File Number: D07-12-21-0180

June 14, 2022

Re: Site Plan Control Application

91 Holland Avenue

Zoning Information: MC16 H(20)  
City of Ottawa Consolidated Zoning By-law 2008-250

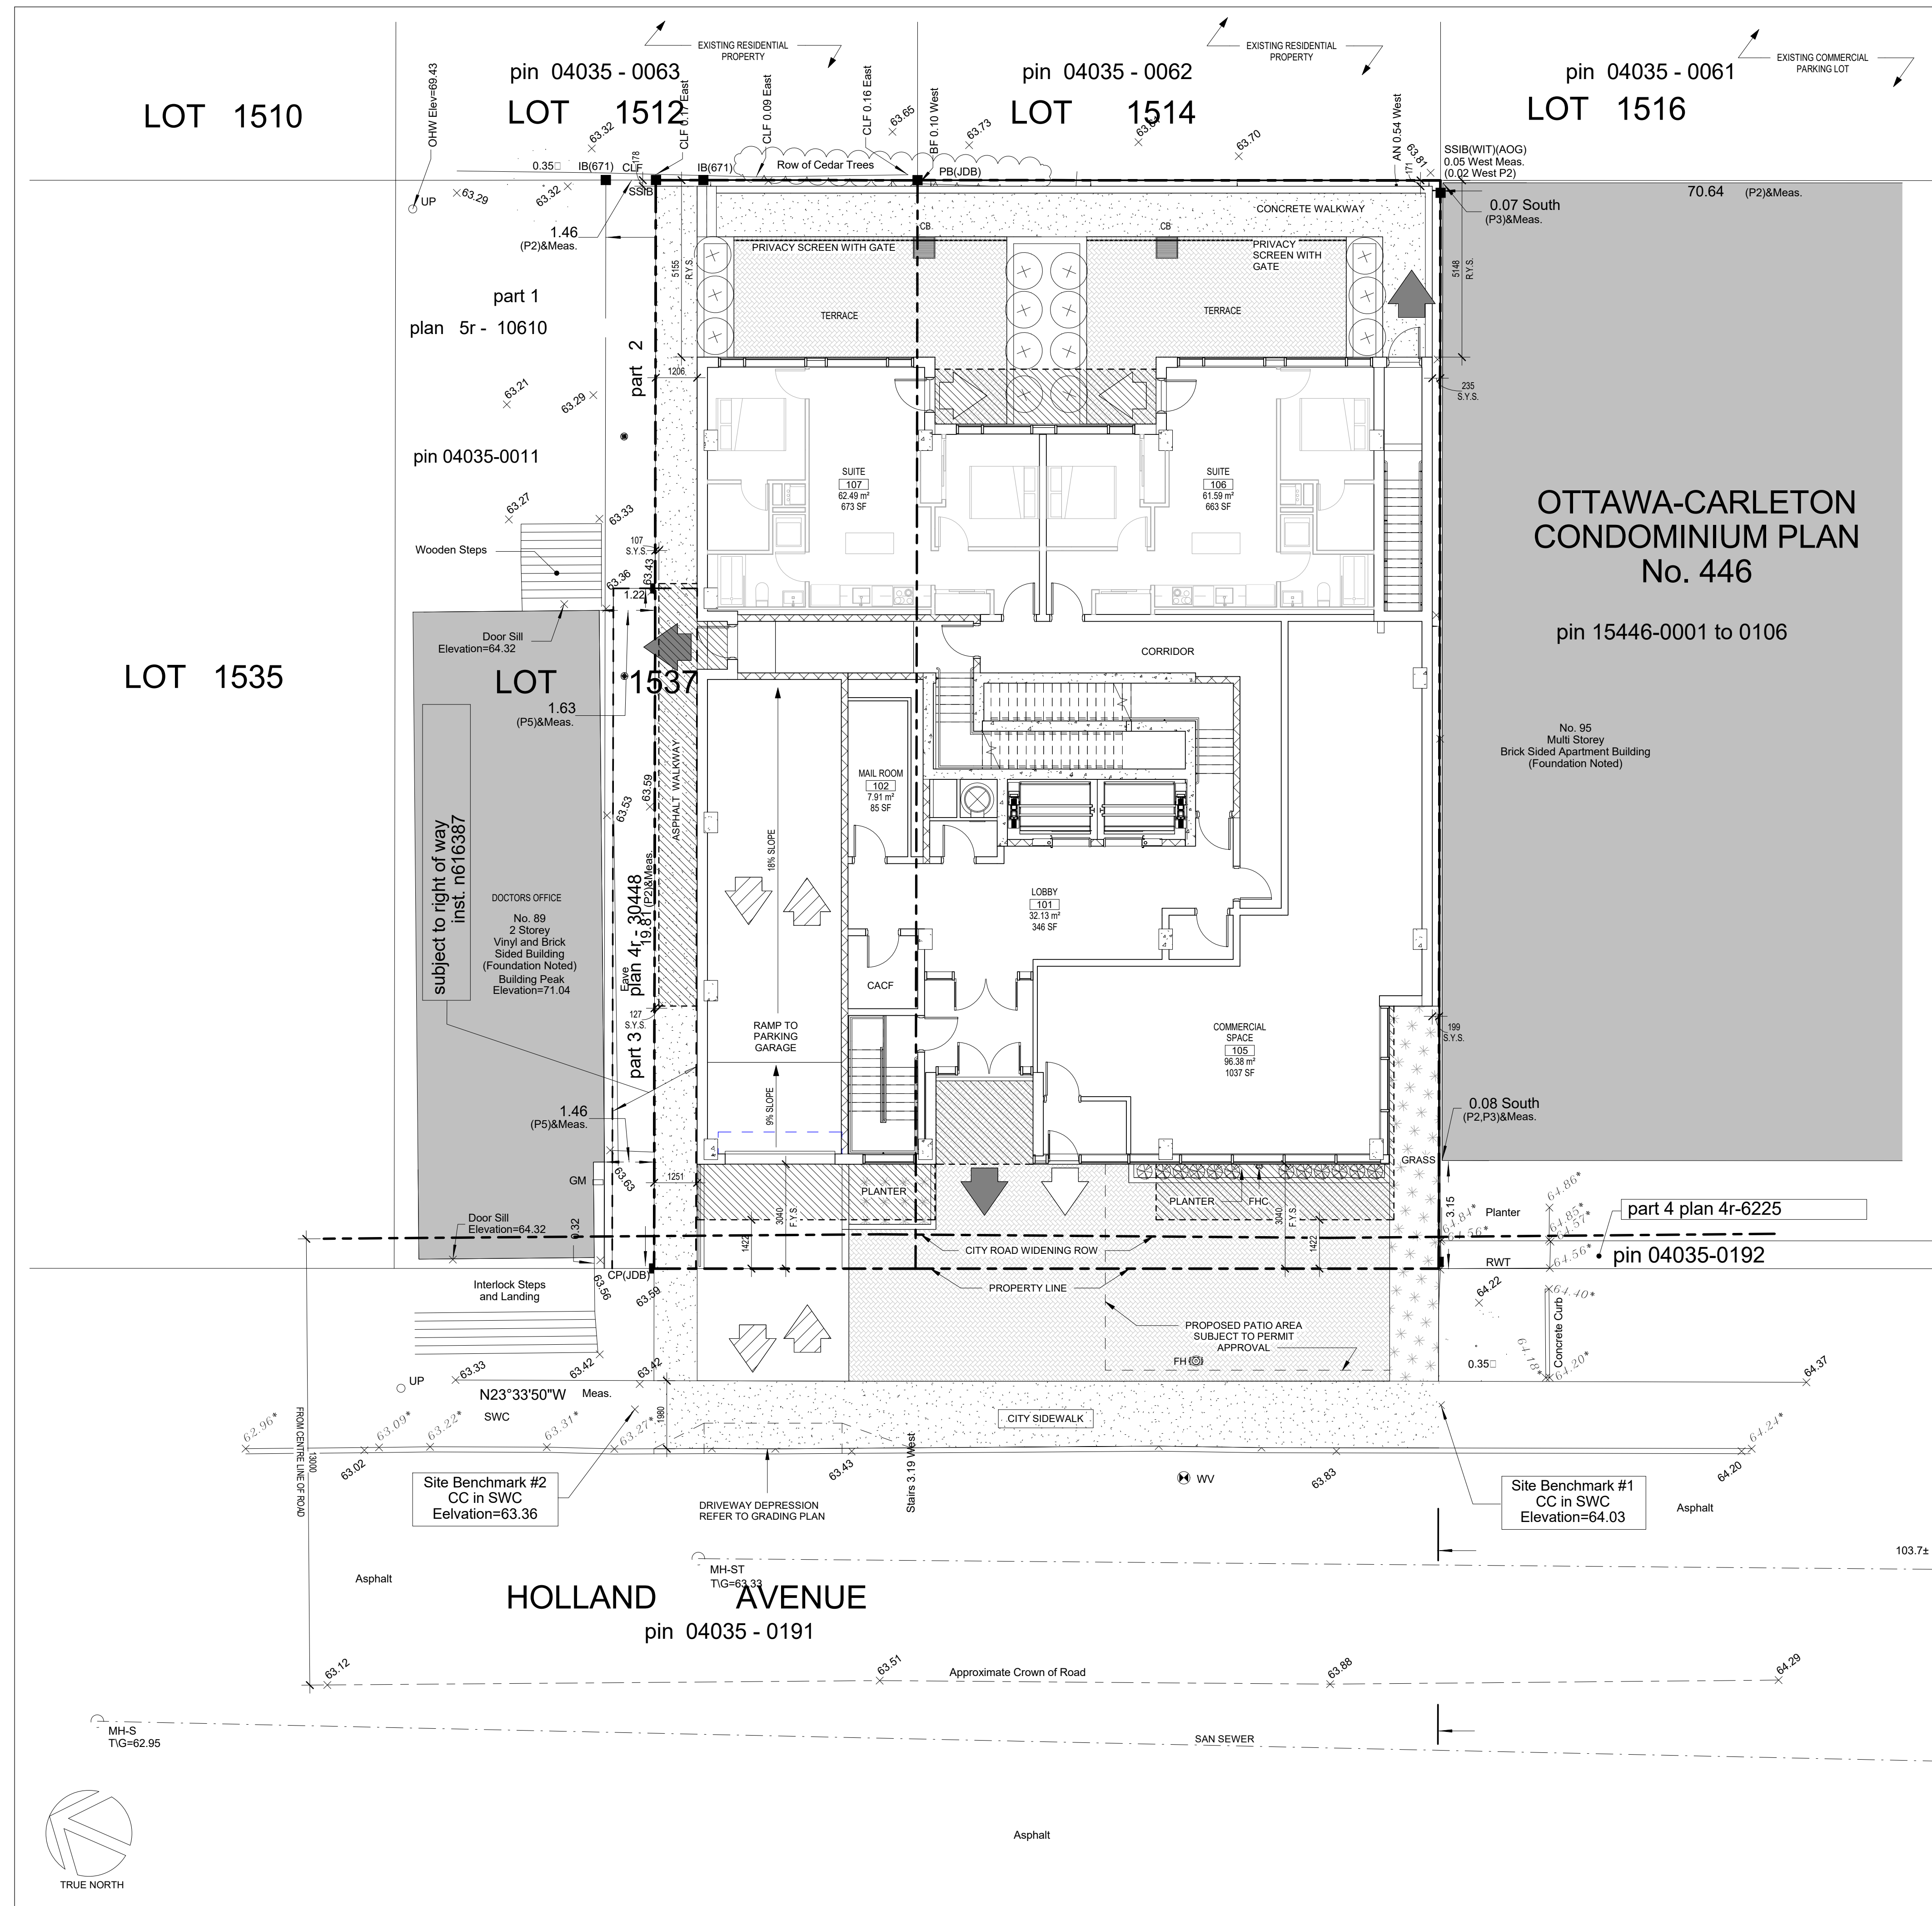
4. Include zoning of the surrounding properties within 5m.
5. *The balconies are not considered permitted projections, as they are enclosed living space.* Some of the balconies, at least on the renderings, were fully enclosed. Please ensure that the balconies comply with Table 65 (6). A maximum of two sides may be enclosed.

**A-101**

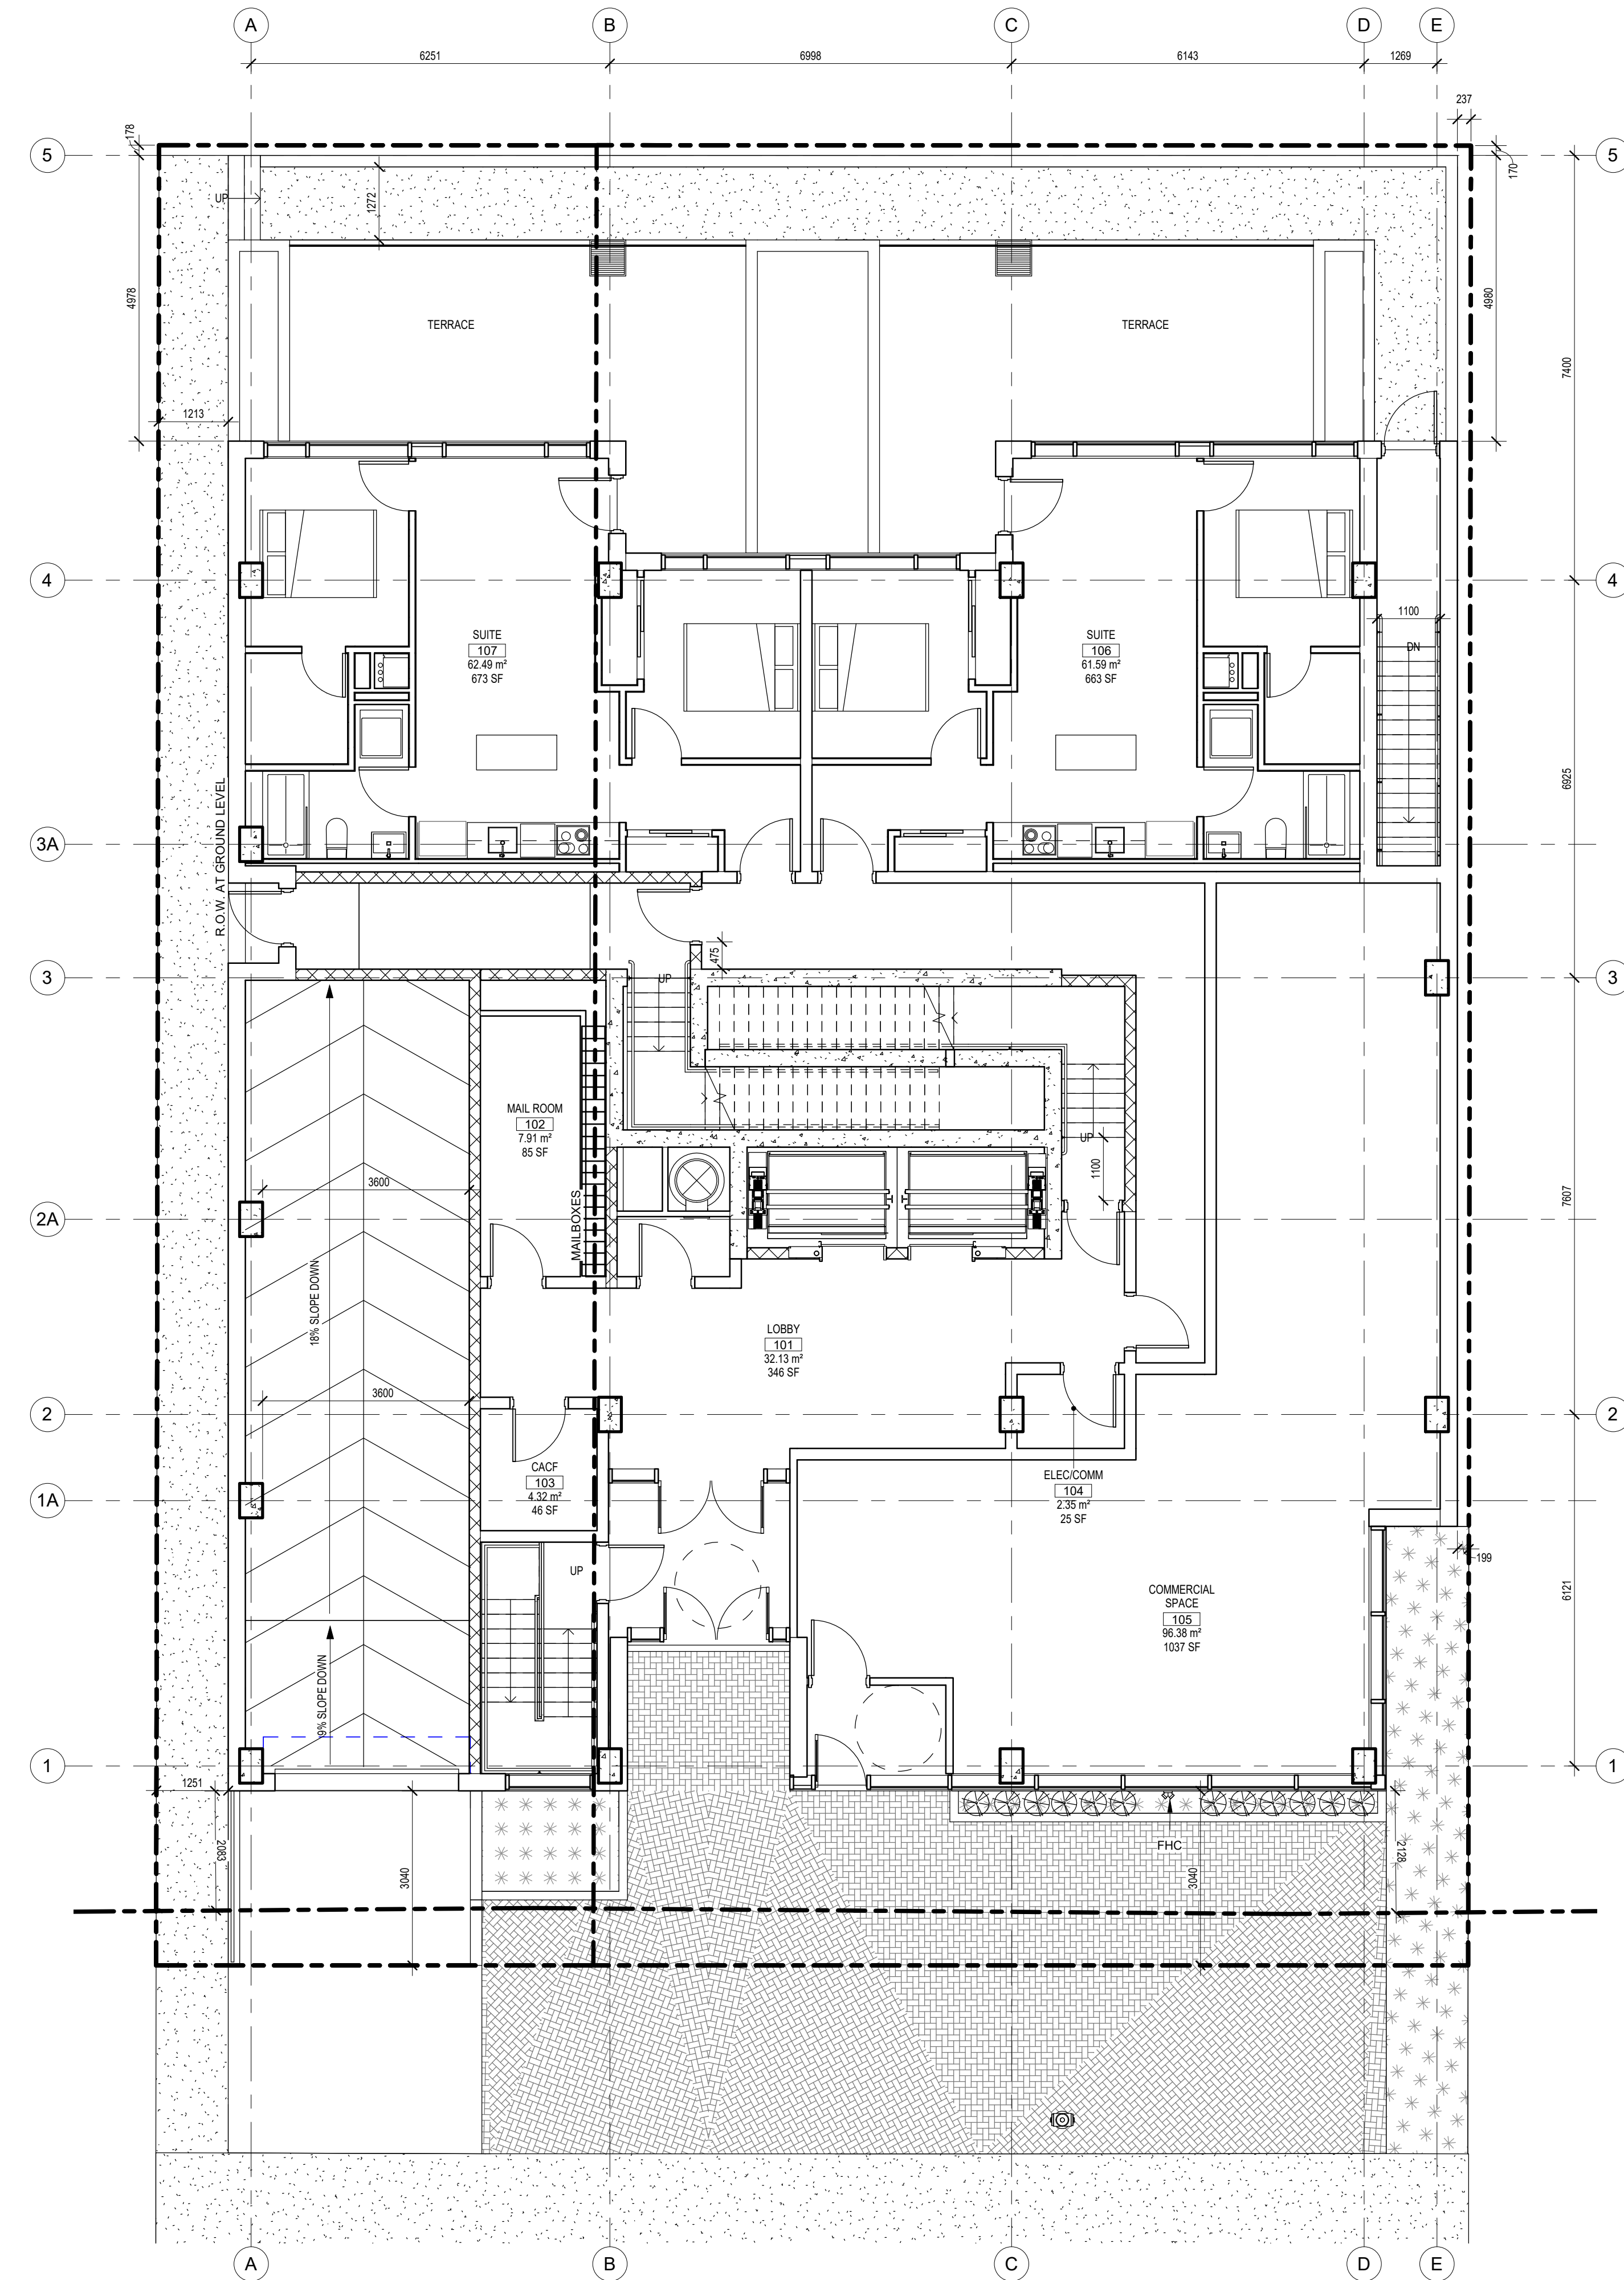
5. The narrow planters in front of the ground floor commercial space is not most conducive to retail/commercial uses.
6. Please study the area between the residential entrance and the commercial entrance in terms of façade treatment and materiality. For example, if a brick wall is to be installed between the residential entrance and the commercial unit, perhaps the wall should have a slightly wider return on the façade to create an alignment with the walls on the upper floors. If the idea is to present the commercial unit as a “glass box”, perhaps the brick wall between the residential entrance and the commercial entrance should be removed and replaced by a glass (see attached diagrams).

They will need to put bigger doors on the garbage room 915mm doors are not big enough and will get damaged.
